**WELWYN HATFIELD BOROUGH COUNCIL
EXECUTIVE DIRECTOR - PLANNING, PUBLIC PROTECTION AND GOVERNANCE**

Application No: 6/2018/0297/LAWP
Location: Manor Cottage Vineyards Road Northaw Potters Bar EN6 4PQ
Proposal: Certificate of lawfulness for the erection of two single storey side extensions and an outbuilding
Officer: Mr David Elmore

Recommendation: Refused

1:100 | MC-R00-PR-103
 SCALE @ A2: | DRAWING No:

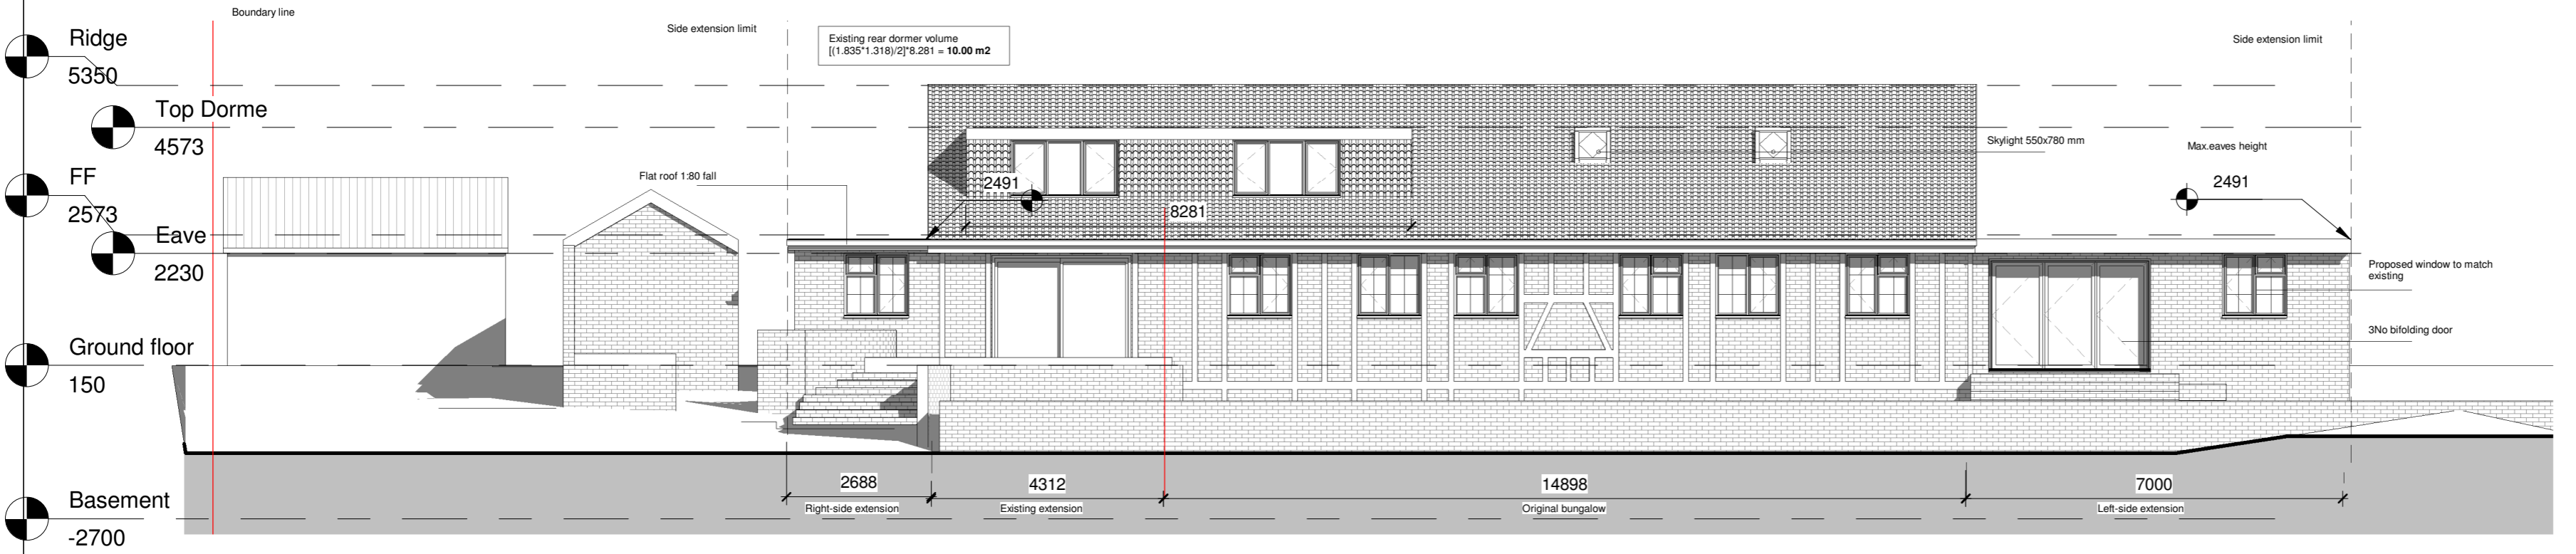
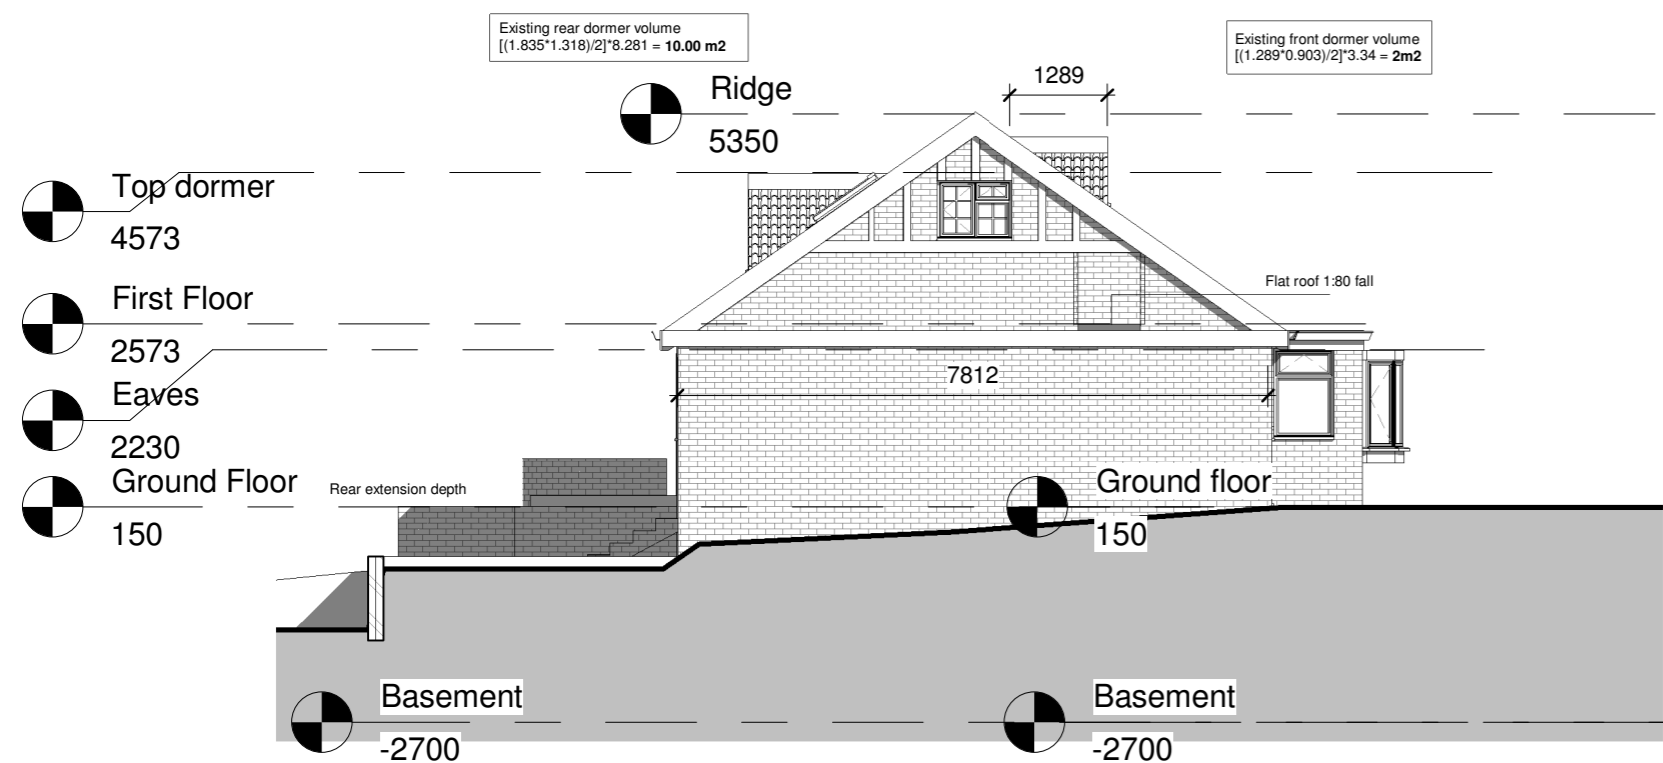
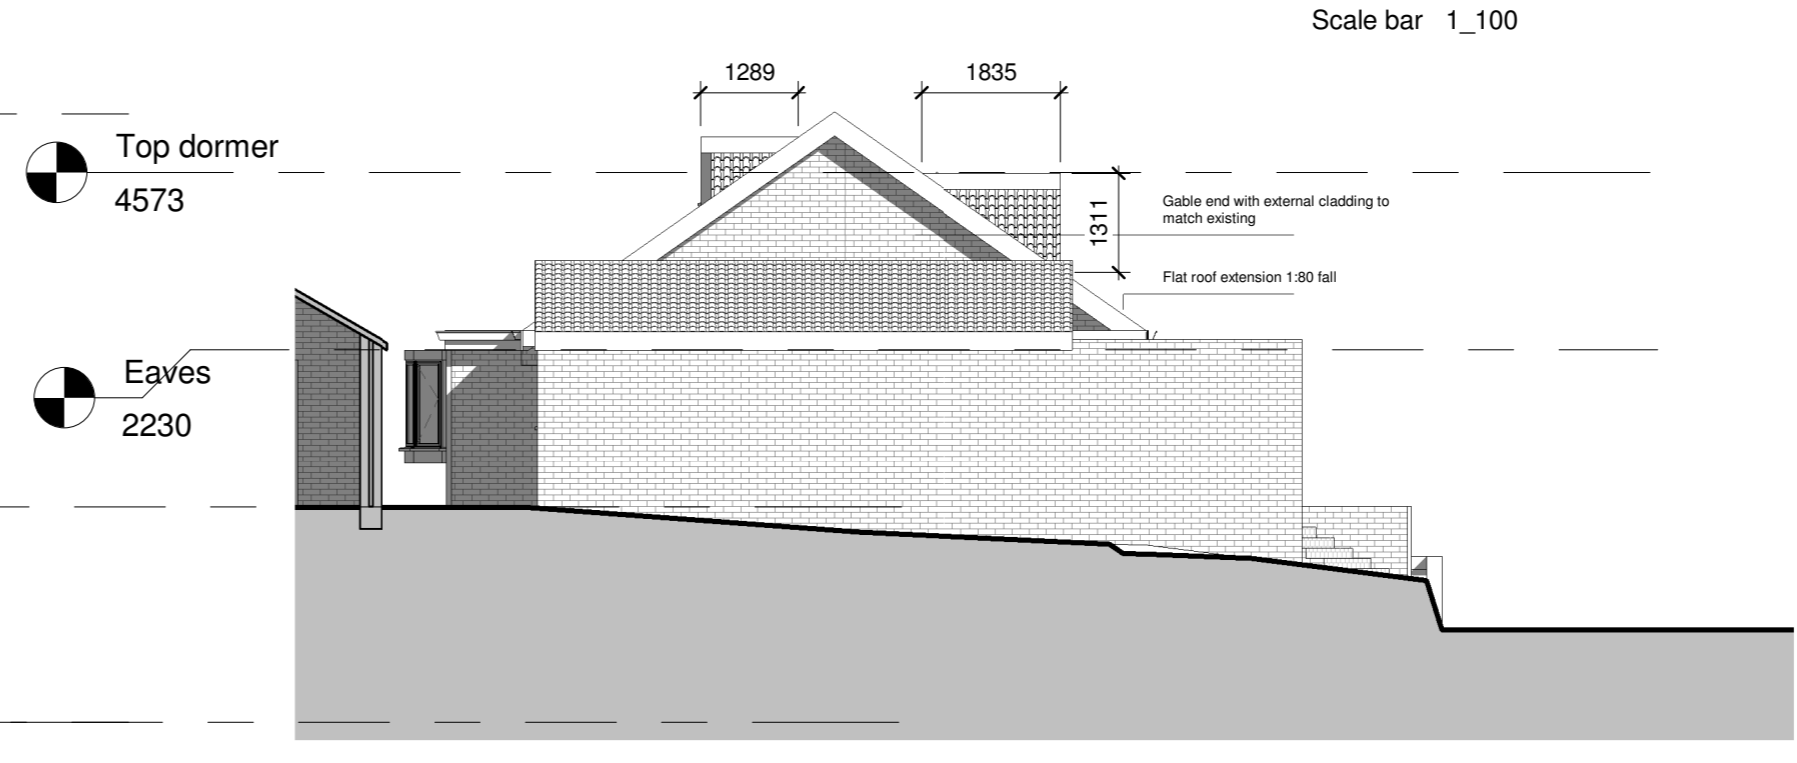
(f) the height of the eaves of the building would exceed 2.5 metres; <u>Reasoning:-</u> <i>The Government sought to provide clarity on matters relating to the interpretation of householder permitted development rights through the publication of Permitted development for householders: Technical Guidance; Department for Communities and Local Government (April 2014) (the Technical Guidance). Where there is a flat roof, the Technical Guidance states on page 12 that “eaves height is measured from the ground level at the base of the outside wall to the point where that wall would meet the upper surface of the flat roof...”</i> <i>In accordance with the Technical Guidance, the proposed outbuilding has an eaves height of 2.866m and exceeds this limitation. The proposed outbuilding is unlawful.</i> <i>The Technical Guidance is intended to provide consistency and to help those involved in the process understand permitted development rules. As Government guidance it is afforded significant weight. Thus, whilst individual builders or architects may have their own views of what constitutes the eaves height of a building it is considered that the advice in the Technical Guidance should be used for the purposes of determining eaves height in relation to the permitted development regime.</i>	Y	N

The proposed outbuilding, by virtue of the size of its wine cellar and larder, would not be reasonably required for a purpose incidental to the enjoyment of the dwellinghouse. Also, the height of the eaves of the proposed outbuilding exceeds 2.5 metres. This building would fail to accord with Schedule 2, Part 1, Class E of the Town and Country Planning (General Permitted Development)(England) Order 2015 as amended.

2. The proposed outbuilding, by virtue of the size of its wine cellar and larder, would not be reasonably required for a purpose incidental to the enjoyment of the dwellinghouse. Also, the height of the eaves of the proposed outbuilding exceeds 2.5 metres. This building would fail to accord with Schedule 2, Part 1, Class E of the Town and Country Planning (General Permitted Development)(England) Order 2015 as amended.

1:100 | MC-R00-PR-102
SCALE @ A2: | DRAWING No:

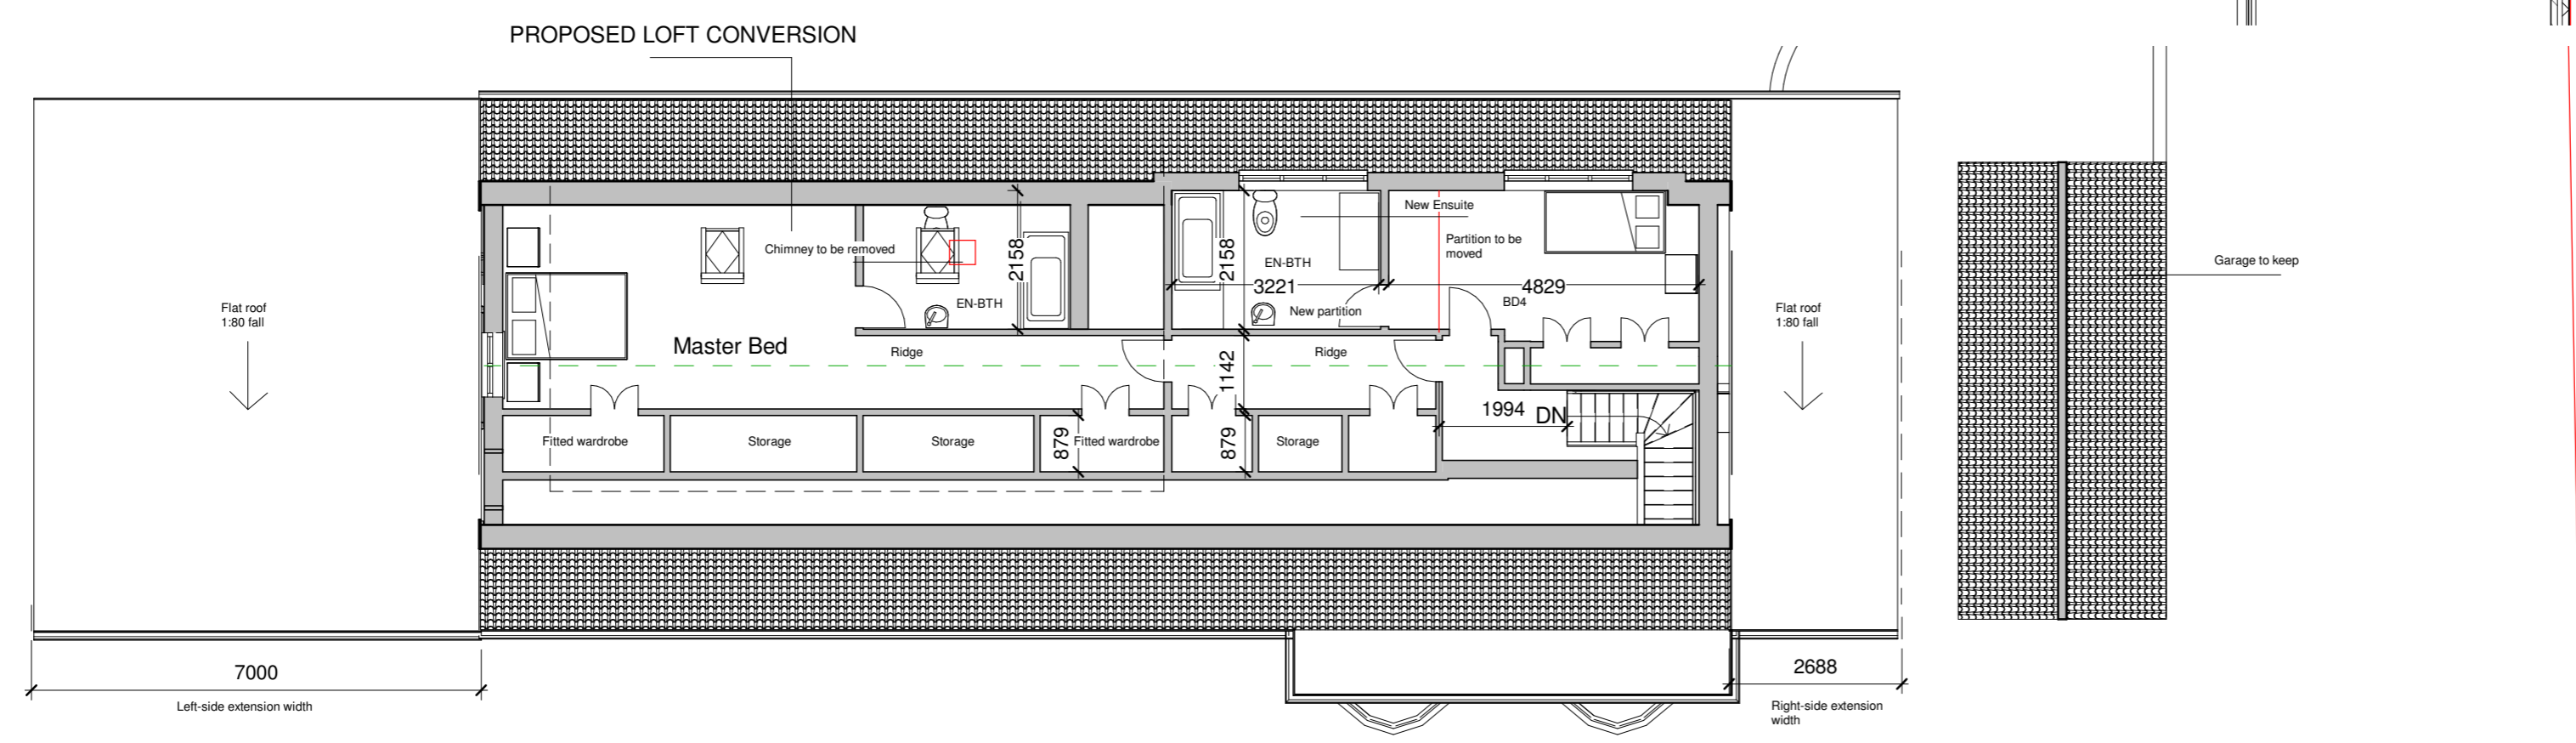
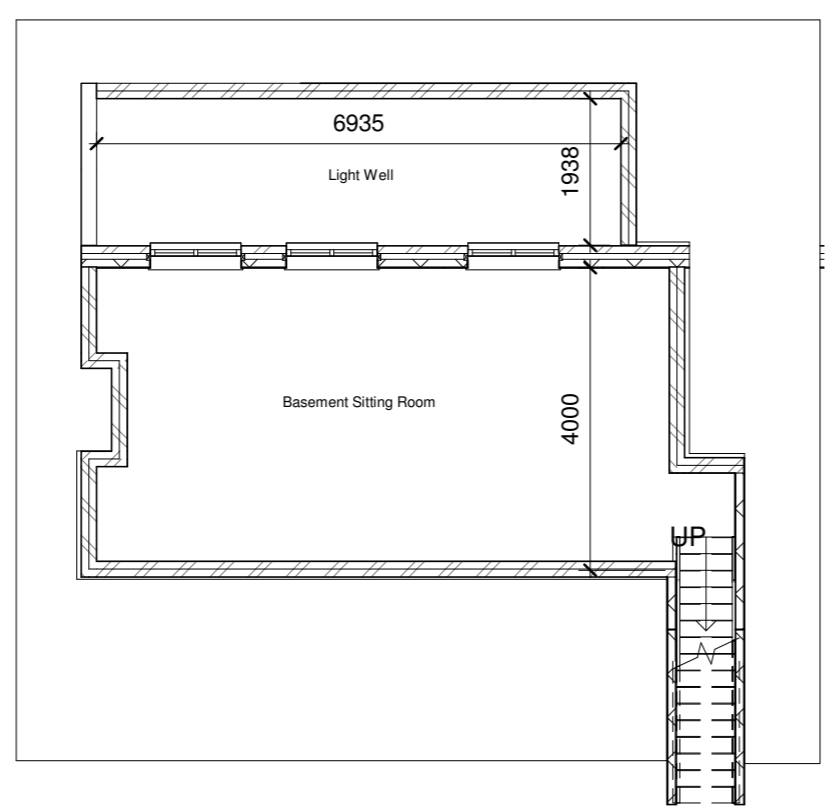
(e) would the enlarged part of the dwellinghouse extend beyond a wall which:- (i) forms the principal elevation of the original dwellinghouse; or (ii) fronts a highway and forms a side elevation of the original dwellinghouse	Y	N

(j) would the enlarged part of the dwellinghouse extend beyond a wall forming a	Y	N

side elevation of the original dwellinghouse, and:- (i) exceed 4 metres in height, (ii) have more than one storey, or (iii) have a width greater than half the width of the original dwellinghouse		
(ja) any total enlargement (being the enlarged part together with any existing enlargement of the original dwellinghouse to which it will be joined) exceeds or would exceed the limits set out in sub-paragraphs (e) to (j); <u>Reasoning:-</u> <i>The original dwellinghouse has been enlarged through a front extension, side extension and complete roof enlargement under planning permissions: E6/1957/1479/ & E6/1969/0499/.</i> <i>The proposed side extension (south-east flank) would join onto a non-original front extension and roof enlargement. As a result, the total enlargement would extend beyond a wall which forms the principal elevation of the original dwellinghouse, exceed 4 metres in height and have more than one storey. The proposed side extension (north-west flank) would join onto a non-original front and side extension and roof enlargement. As a result, the total enlargement would extend beyond a wall which forms the principal elevation of the original dwellinghouse, exceed 4 metres in height and have more than one storey. The proposed side extensions would fail to comply with Schedule 2, Part 1, Class A, A.1(e, j and ja) of the Town and Country Planning (General Permitted Development)(England) Order 2015 as amended.</i>	Y	N

The proposed side extensions would join onto existing enlargements of the original dwellinghouse, exceeding the limits set out in Schedule 2, Part 1, Class A, A.1, e, j and ja, of the Town and Country Planning (General Permitted Development)(England) Order 2015 as amended.

1. The proposed side extensions would join onto existing enlargements of the original dwellinghouse, exceeding the limits set out in Schedule 2, Part 1, Class A, A.1, e, j and ja, of the Town and Country Planning (General Permitted Development)(England) Order 2015 as amended.
